CITY OF ALBUQUERQUE

PLANNING DEPARTMENT – Development Review Services

RE: Sunset Gardens Subdivision (File: K12D003)
Grading and Drainage Plan, Engineer's Stamp Date 1-19-15
Drainage Report, Engineer's Stamp Date 1-16-15

TITLE: **SUNSET VILLA**
GARDEN WAY STORM DRAIN IMPROVEMENTS 2

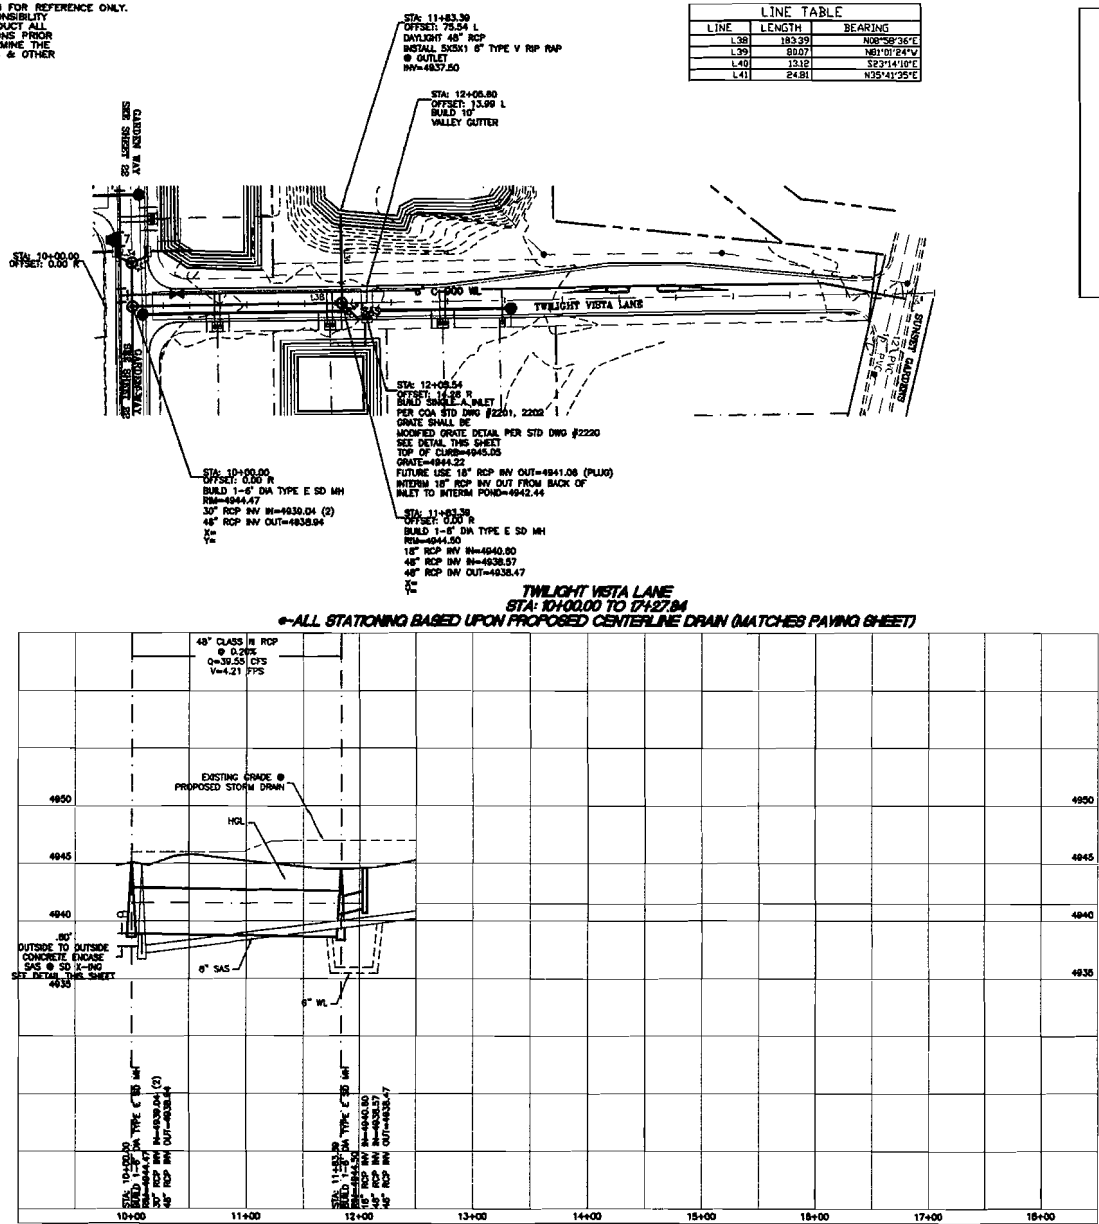
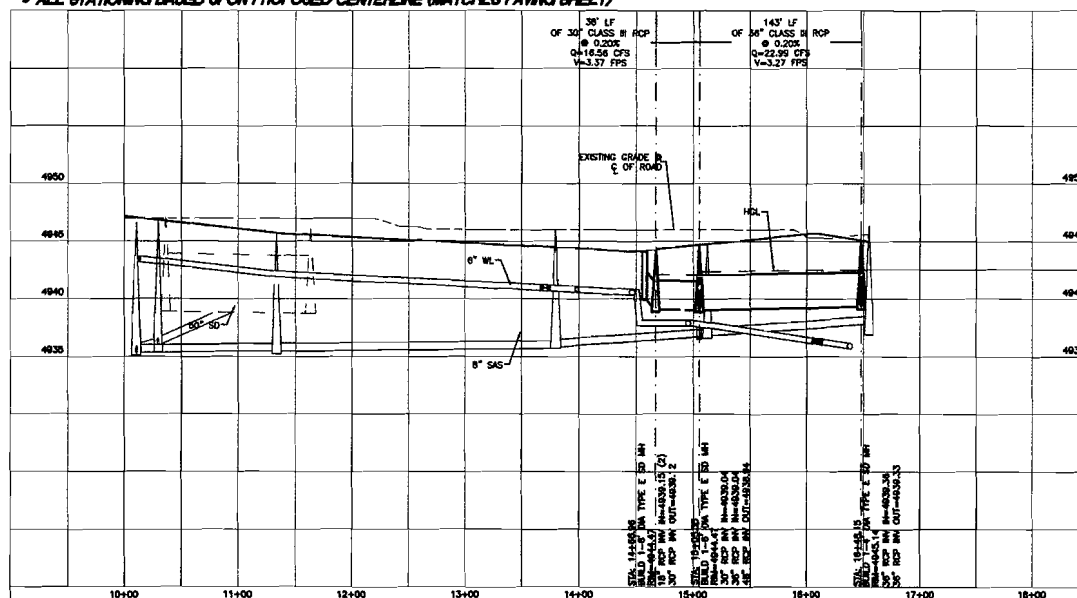
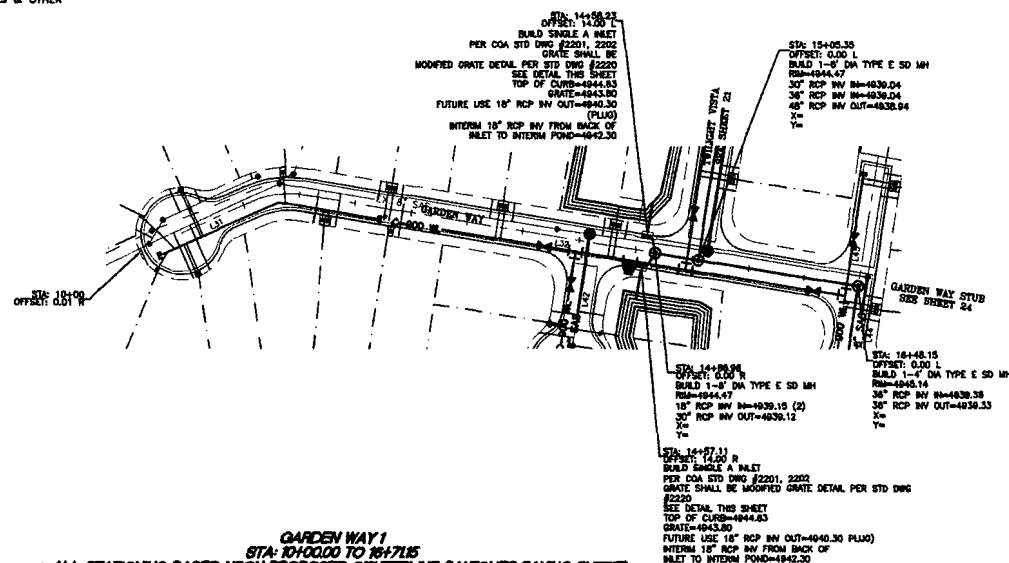
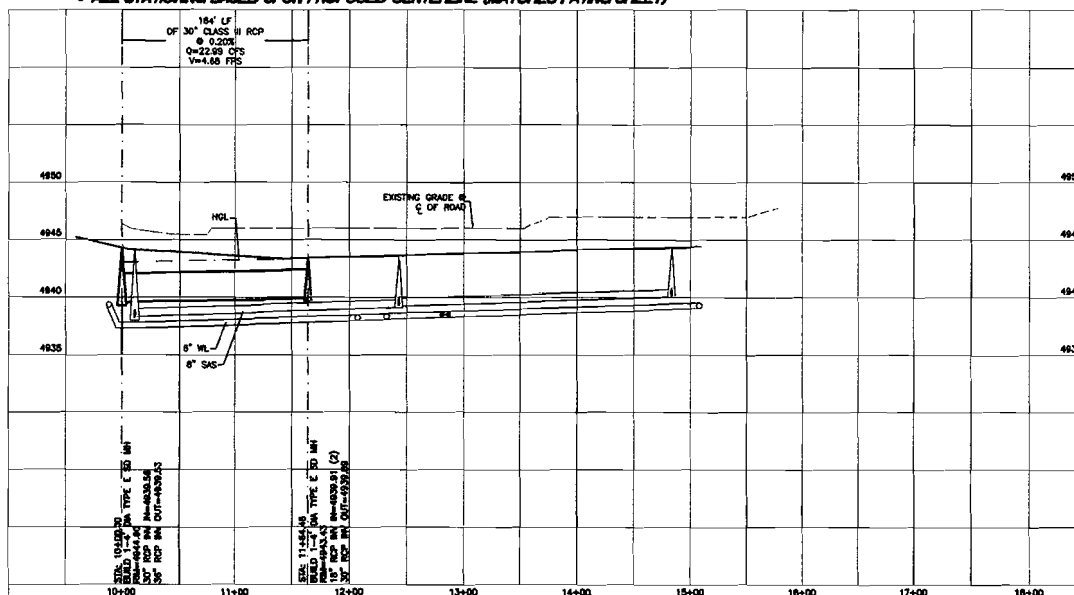
6. If inlet is in sump condition, state so. Sump catch basins need to be designed for 2x 100yr storm, or other criteria in DPM pg 22-154.
7. Inlets into all the Ponds: (shown also on Work Order)

- a. the invert at pond is higher than invert at inlet
 - b. the Top of Curb is 1.43' higher than the grate elevation for Ponds A,B
 - c. The Grate Elevations shown are the Flowline elevations

- d. Invert elevations of the 18"dia. into pond is about 1.5' above the Max. allowed invert elevation per detail 2202, Note B. Invert is also higher than "future use" invert. Hydrology would prefer for the inverts into pond to be lower than the "future use inverts." When the inverts to the pond are plugged in the future, lean fill can be poured to slope the bottom of the inlet to the "future use" invert. A special detail will need to be on the work order and G&D plan.

SUNSET VILLA GRADING AND DRAINAGE PLAN	DRAWN BY: MCKI DATE: 1-19-15 21401-1000-1-06-13
	1/19/15 DAVID SOULE P.E. #14359	Rio Grande Engineering 1400 CENTRAL AVENUE, SUITE 200 ALBUQUERQUE, NM 87102 (505) 975-0000

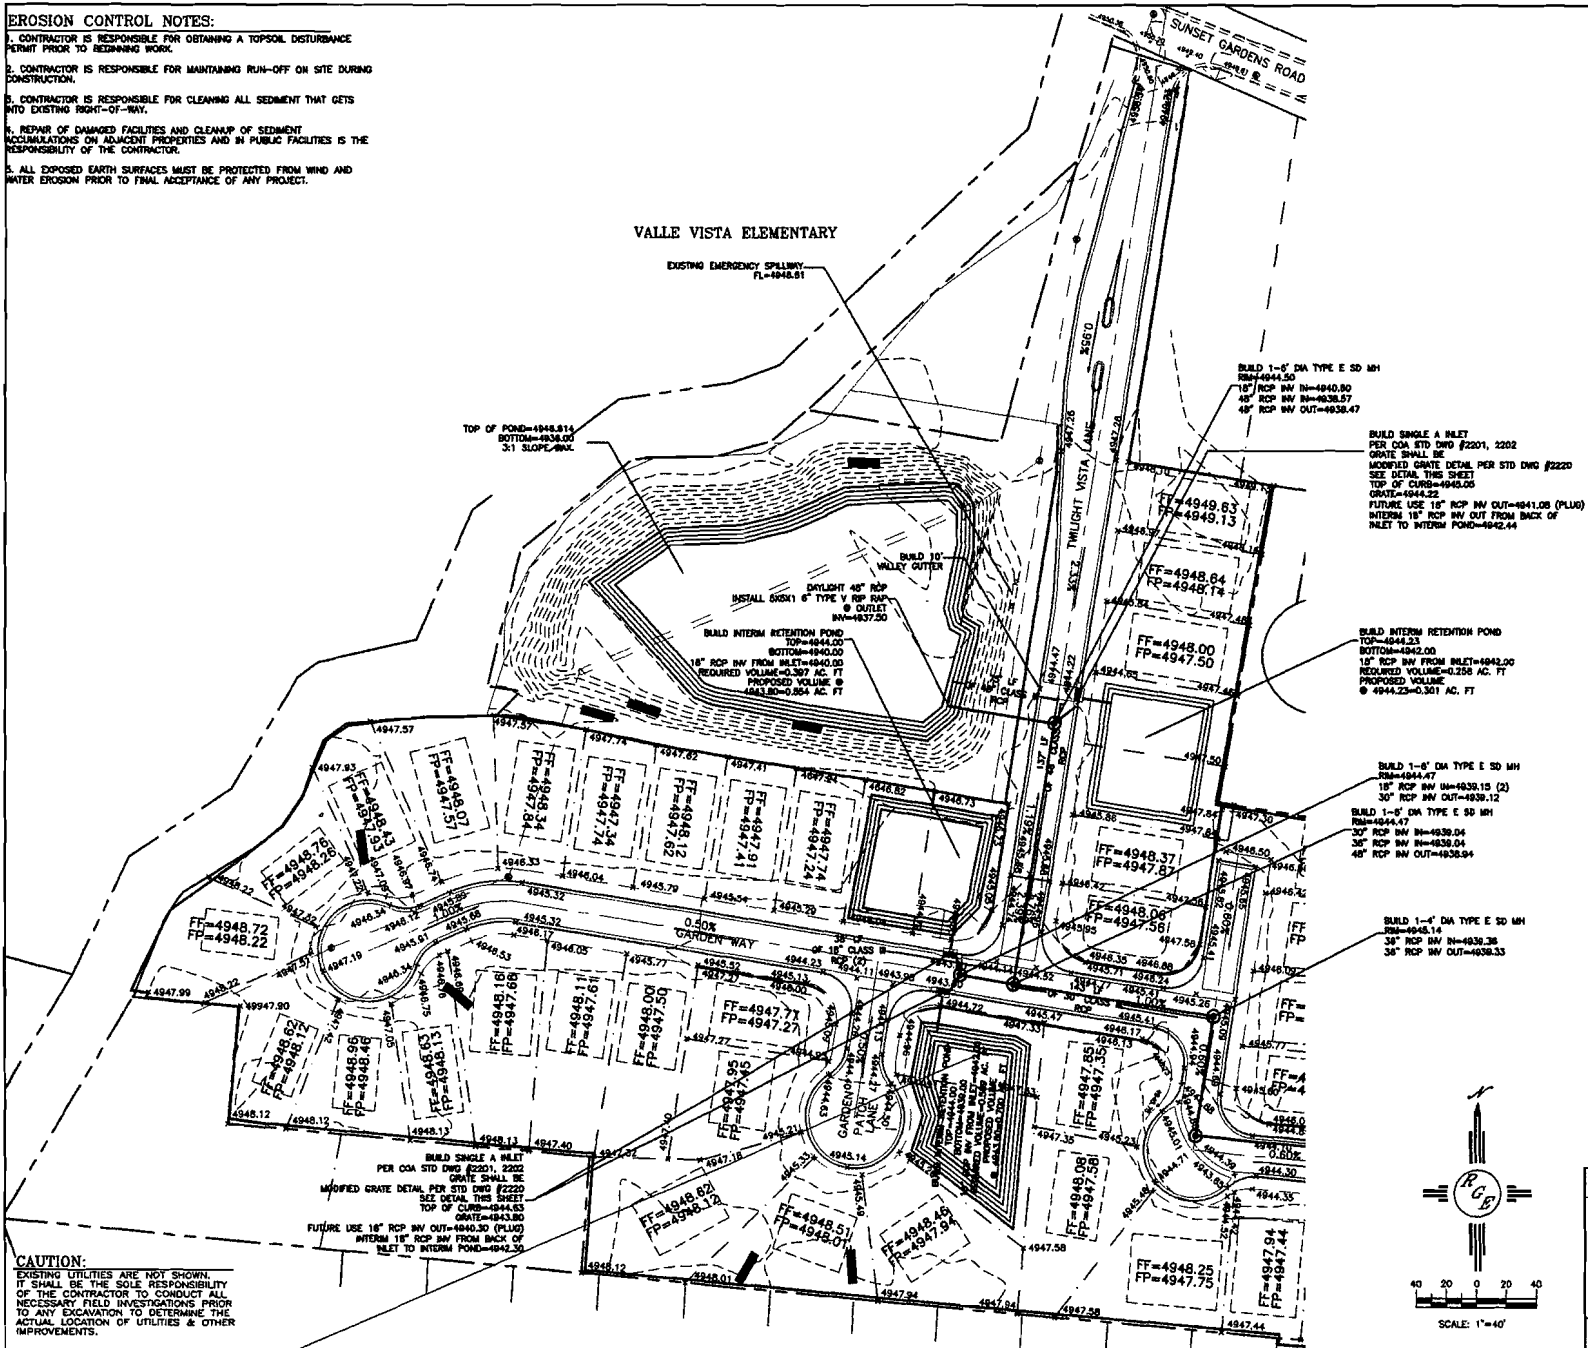
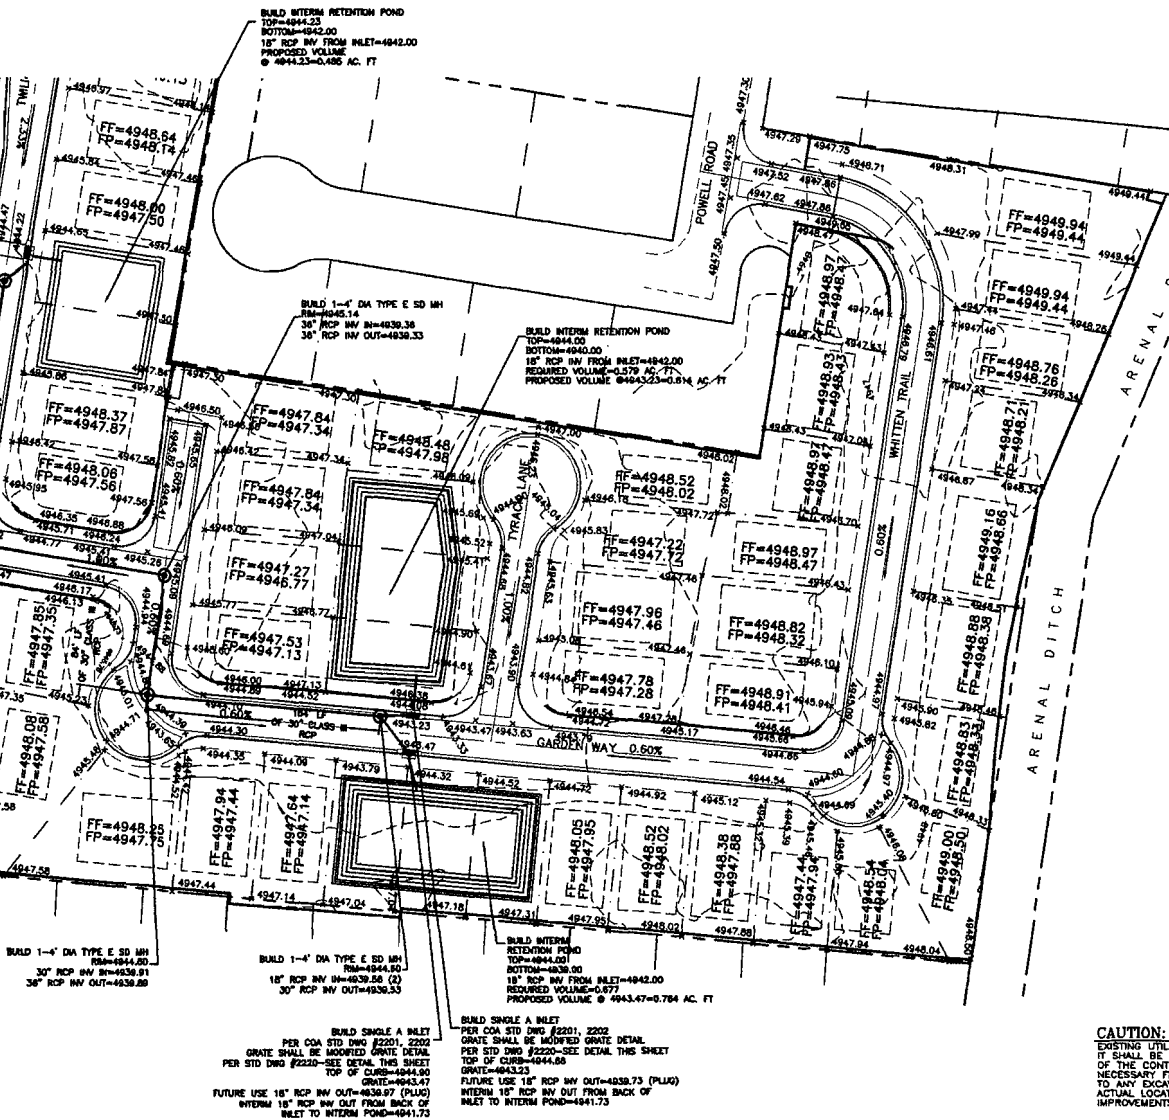
1. Temporary ponds cannot be on lots and must be on tracts. Therefore you will have to come in through DRB to amend the plat and revise the infrastructure list.

4. Lots 68 and 5 have an irrigation and utility easement thru them which should be shown on the Grading Plan. The pad crosses the easement. All easements should be shown on grading plan, including the utility easement.

5. Roadway tracts will need to have drainage easements.
6. Show the flood zone on the plan. A Flood plain permit will be required.
7. You may need to remove the wall, or provide opening in the wall behind lots 46 thru 49 so that the BFE will equalize within the present flood zone boundary. Once the pond is removed in the future, there needs to be some means of equalizing the BFE of the flood zone.

8. Provide a Benchmark and Datum.
9. If Lot 39 is owned by County, note so, and remove pad.
10. The dashed line along the roadway tract – is this the property line? If so, it is not in the same line type as the property line.

11. Show lot numbers on Grading Plan
12. On each pond indicate the Emergency Spillway and the MWSEL
13. The Land Treatments (A,B,C,D) do not add up to 100%.
